From: Roger Spencer
Sent: 03 January 2018 17:00
To: Planning.Responses
Subject: RE: Please find attached amendment on planning application Ref: LU/367/17/PL

APPLICATION NO: LU/367/17/PL

Registered: 03-NOV-17
Site Address: 51 Pier Road Littlehampton BN17 5LP

Description of Works: Change of use of first floor flat (C3 Dwelling House) to restaurant (A3 Food & Drink) & ground floor rear extension and alterations to front elevation.

Shopfront visuals
(Rev A)

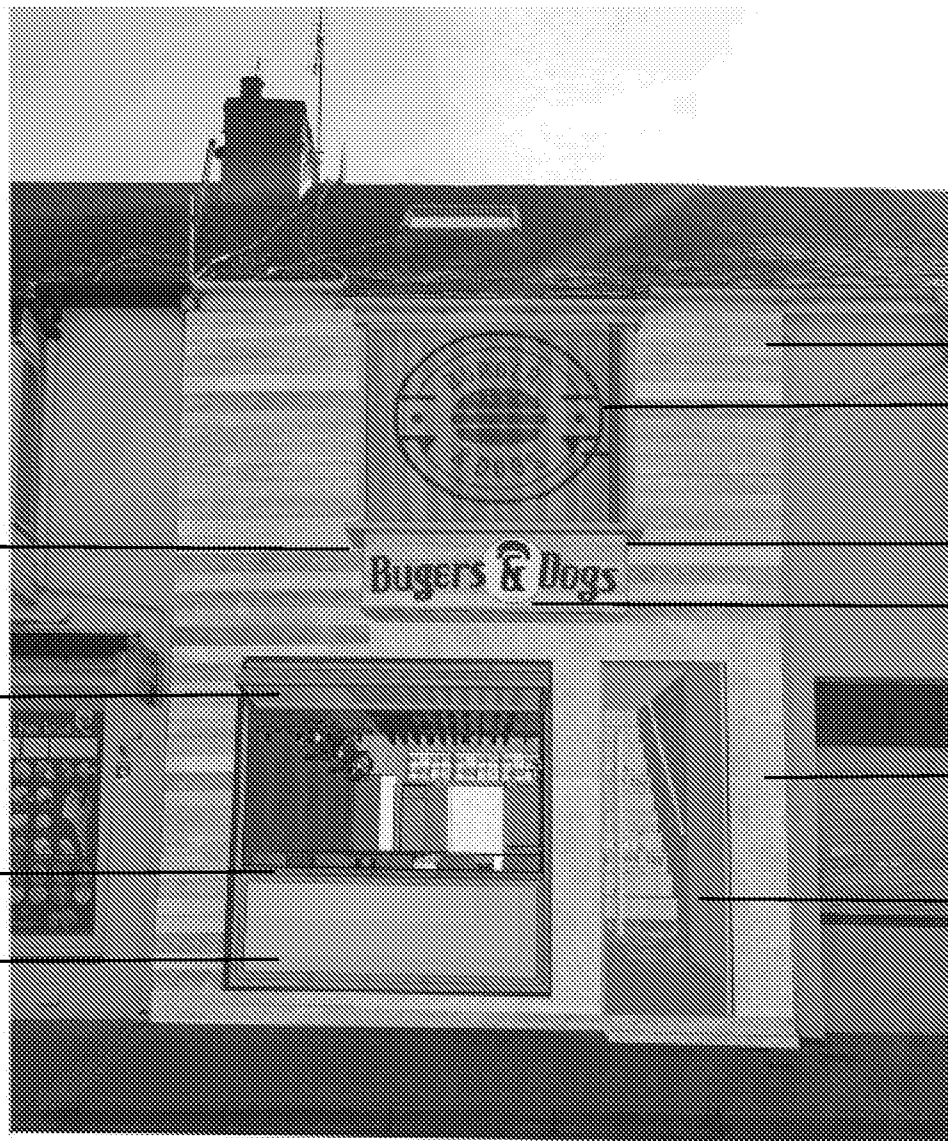
Fenestration – the front ground floor window would seem to have a folding window arrangement that provides for a serving hatch onto the public highway. I have a concern that one or more of the panes would project, when opening or when open, over the public highway and thus be a risk to members of the public going past the site. The window needs to wholly open inwards.
